Our Ref: P/58/18/HH
Your Ref:

Town & Country Planning Act 1990 (as amended)
Town & country Planning (Development Management Procedure) (England) Order 2015
Application for Planning Permission for Works or Extension to a Dwelling

Development First floor dormer extension to front, single storey rear extension & infill porch below existing roof overhang at front.
Location 42 Sea Lane Pagham

EXISTING ELEVATIONS

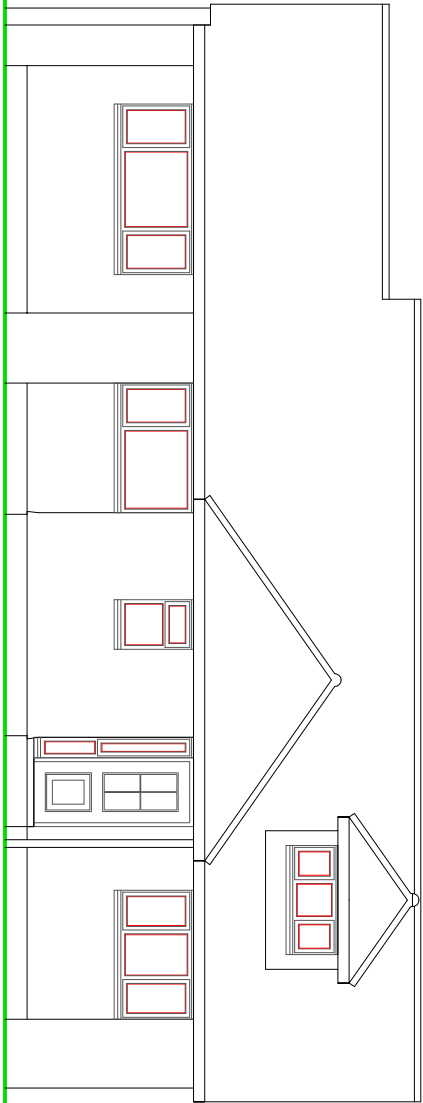
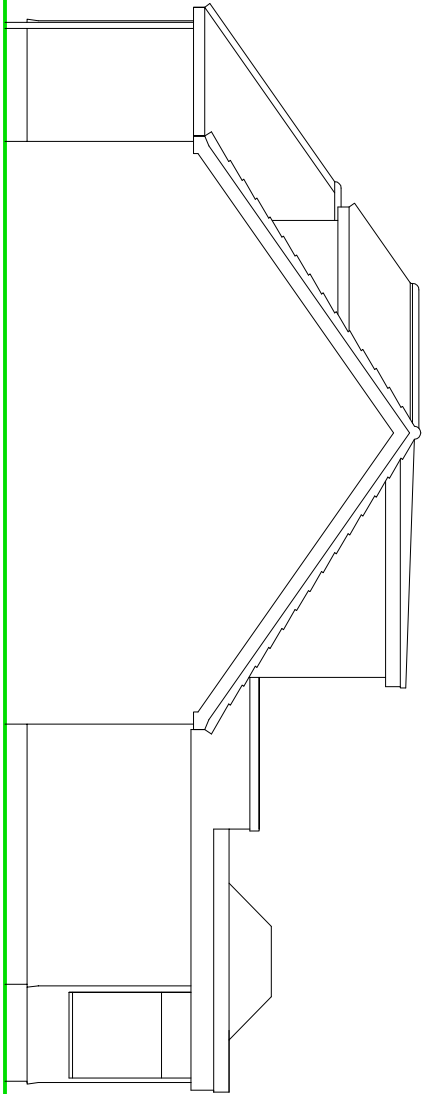
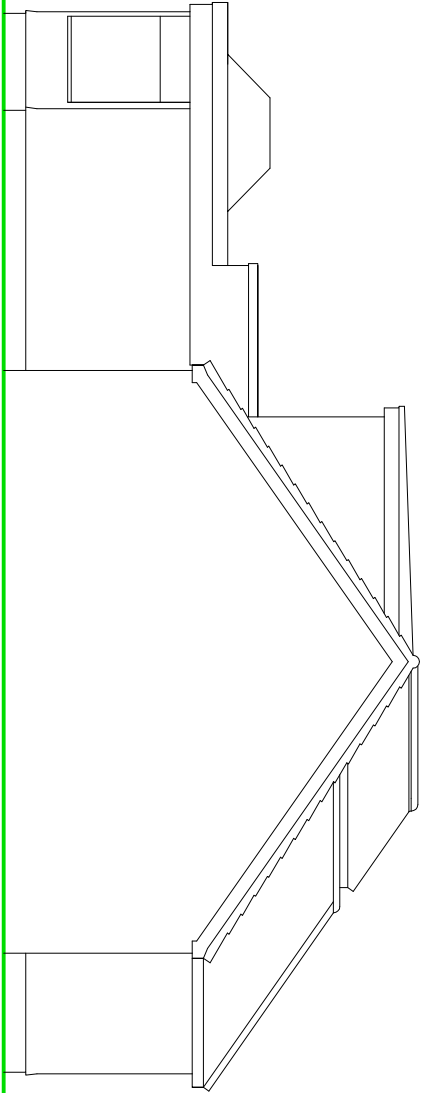
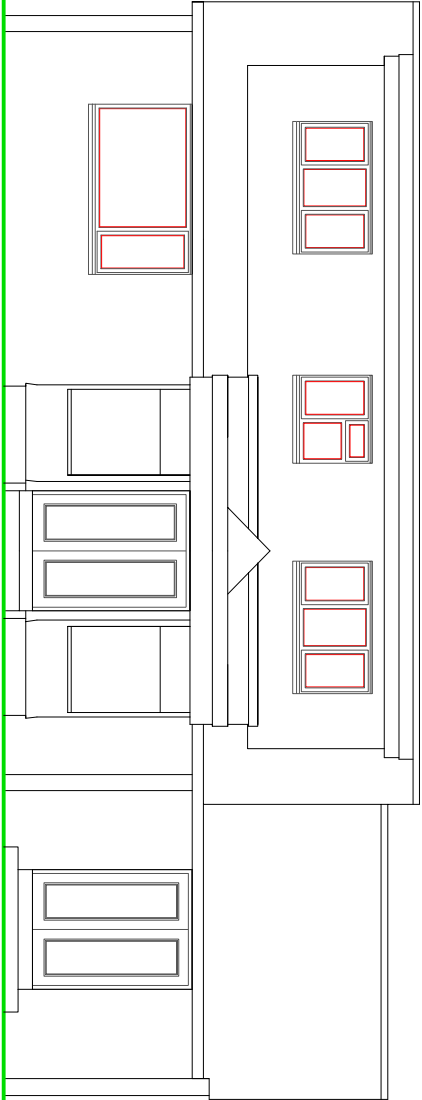
Two sets of existing elevations have been provided. Please label the correct elevations as proposed.
